Response to Comments

Project Name: 104th (Dell's Nursery) Rezone/Site Plan
 Project File Number: PA22041
 Review Completion: December 22, 2022

Preliminary Site Plan

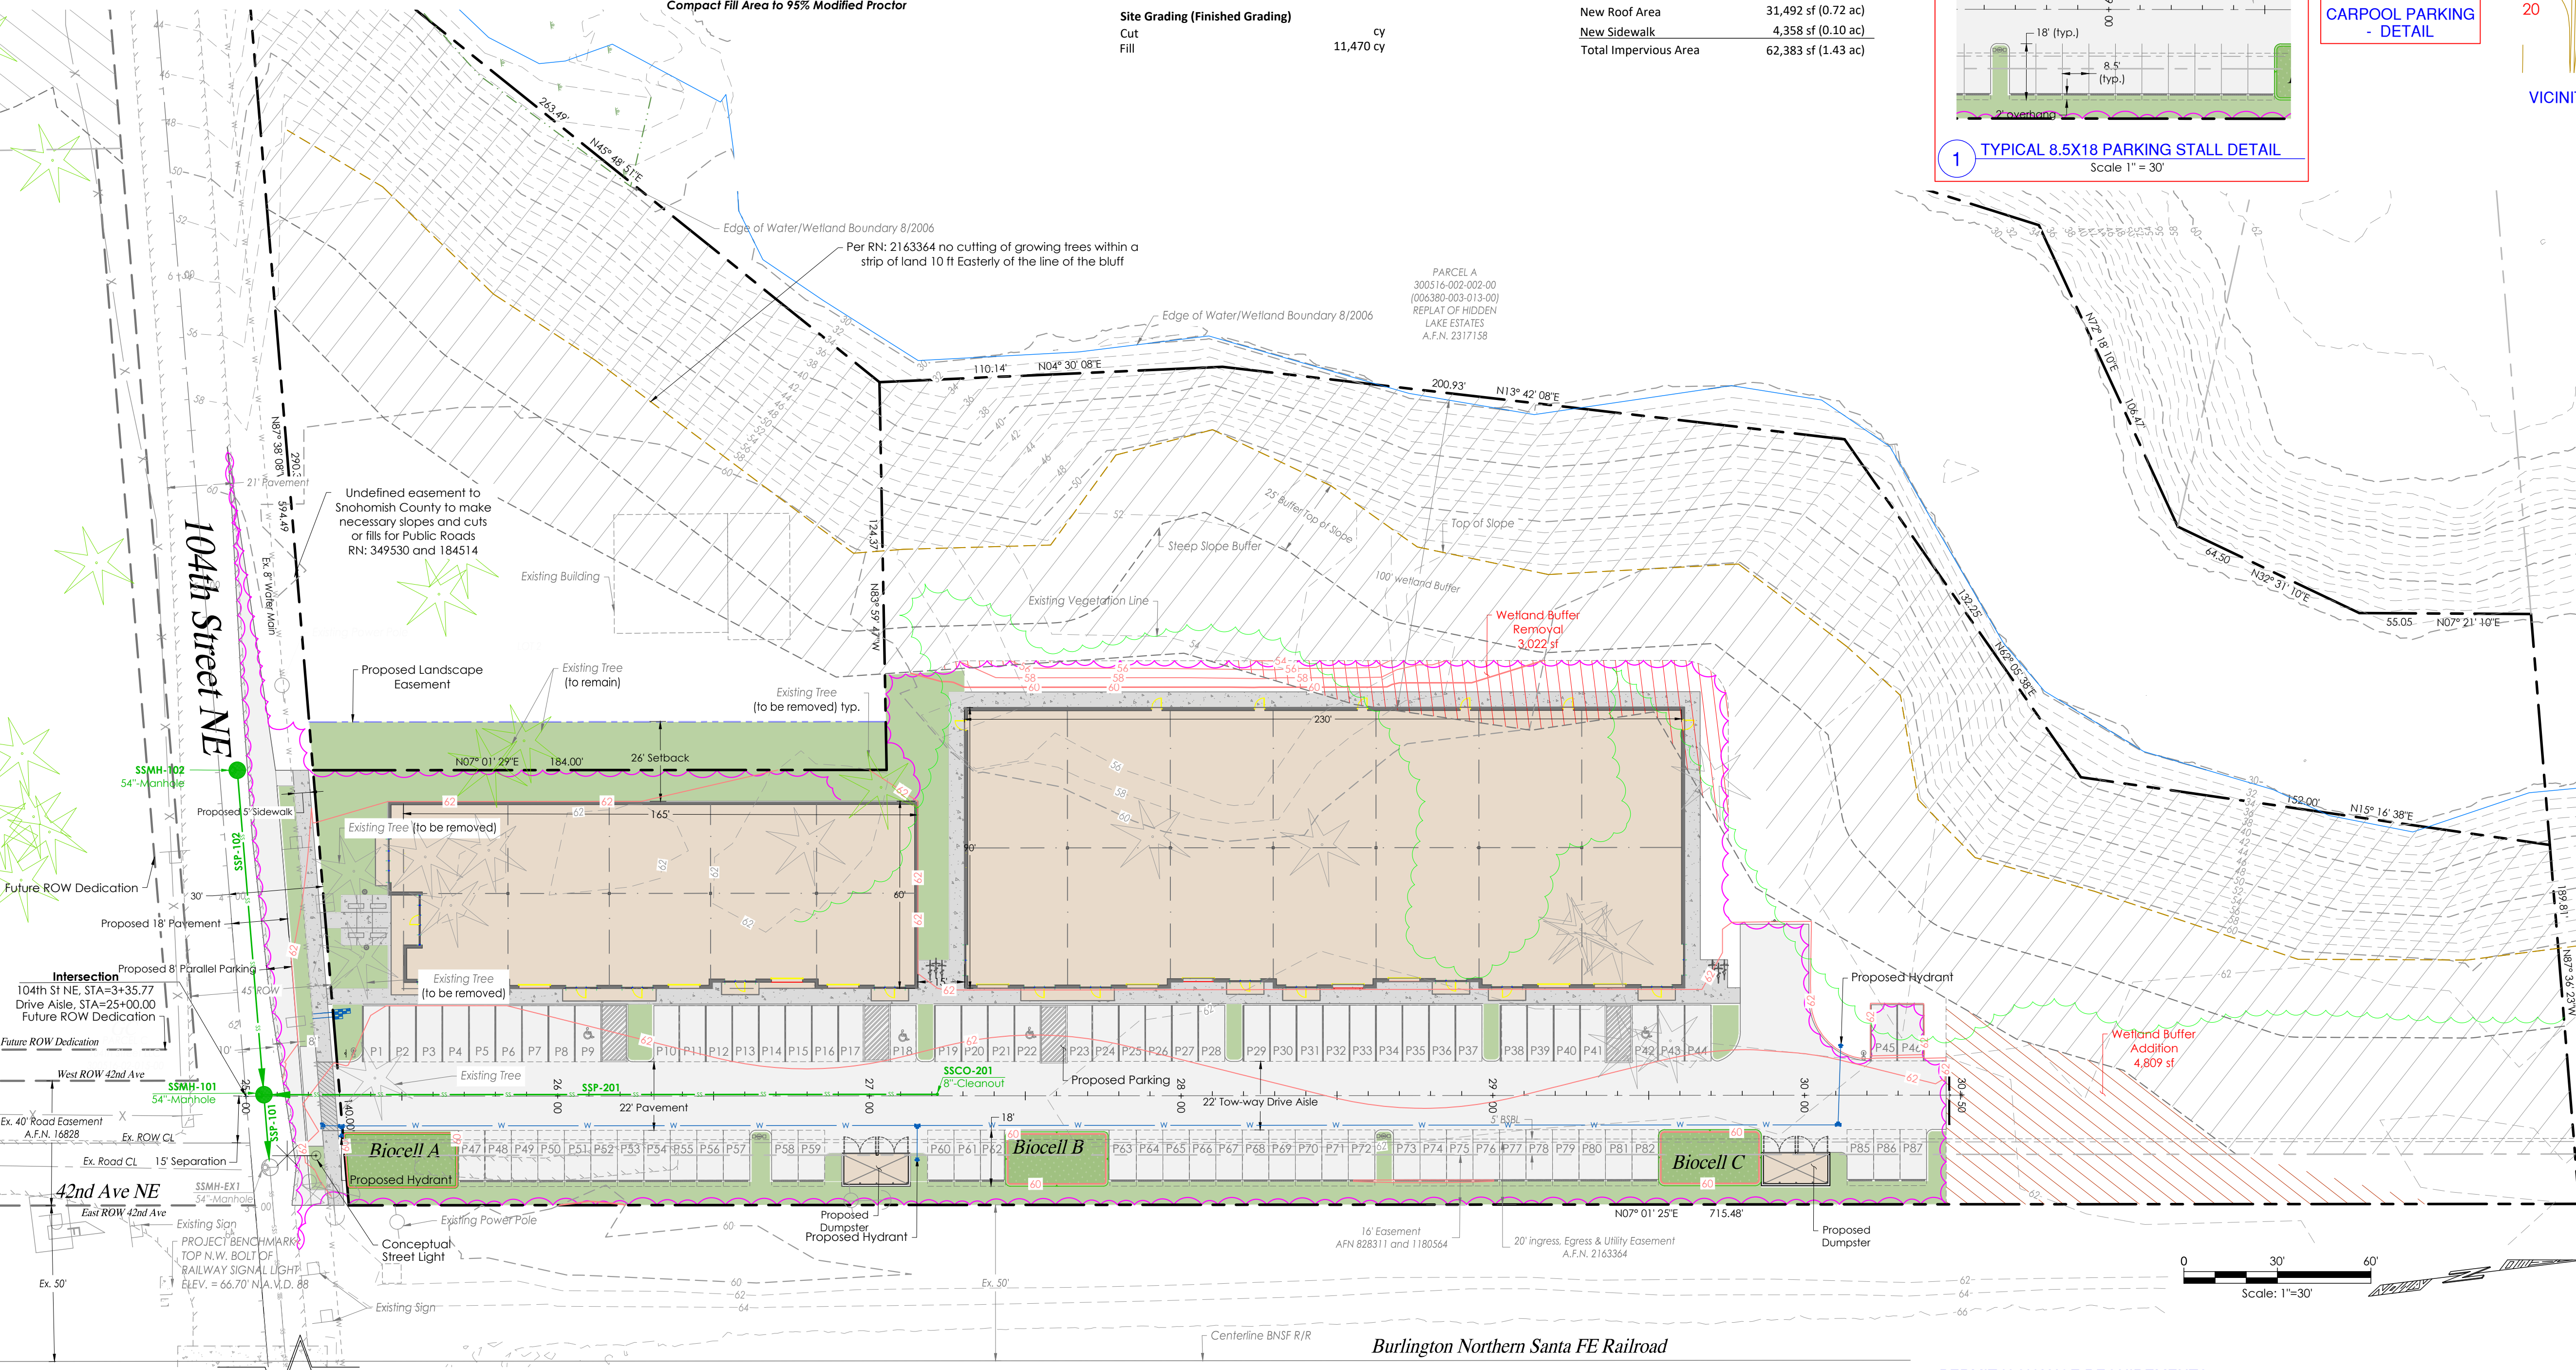
CITY COMMENTS	LAND TECH RESPONSE
<p>egress site distance issues related to the elevated BNSF RR crossing. Please review for sight distance and provide a response.</p>	<p><i>the property on the south side of 104th and will be submitted for a Site Plan Approval on that property later this year.</i></p> <p><i>The Driveway location provides better separation from the tracks and improved site distance. The Centerline offset of the access point and Center of ROW on 42nd is about 15'.</i></p>
<p>4. Provide an existing conditions survey of the site that depicts, or references, if unable to depict, all of the encumbrances outlined in the Title Report prepared by First America Commitment, dated October 11, 2021.</p>	<p>Encumbrances added to Sheet P1 and Sheet P2. Encumbrances are labeled on map.</p>
<p>5. Amend Sheet P1, as follows:</p> <ul style="list-style-type: none"> a. Rows of parking are required to be located no greater than 45' from a minimum 5' wide landscaped island. Parking stalls P19 - P28, P47 - 57 do not comply with this requirement. Additionally, a landscaped island is required on the north side of P44, north and south side of P45 & P46 and north side of P87. b. The proposed solid waste collection areas shall be landscaped on the north and south sides with a minimum 5' wide landscape island. c. Provide bicycle parking calculations in accordance with MMC 22C.130.060. d. Provide carpool parking calculations in accordance with MMC 22C.130.030(3). e. Provide a detail of the required carpool parking signage. Signs must be posted indicating these spaces are reserved for carpool use before 9:00 a.m. on weekdays. f. Add the following notes: Prior to civil construction plan approval, the applicant shall be required to demonstrate compliance with the applicable landscaping standards outlined in MMC 22C.020.250(4) and MMC Chapter 22C.120 	<p>Parking Lot Landscape updated to meet criteria with LS Islands at 45' from all parking stalls.</p> <p>Landscape Island added</p> <p>Collection facility has landscape around the three sides.</p> <p>Bicycle calculation has been added on P1.</p> <p>Carpool parking calculation has been added on P1.</p> <p>Sign Detail Added to Sheet P1</p> <p>The following notes have been added on P1.</p>
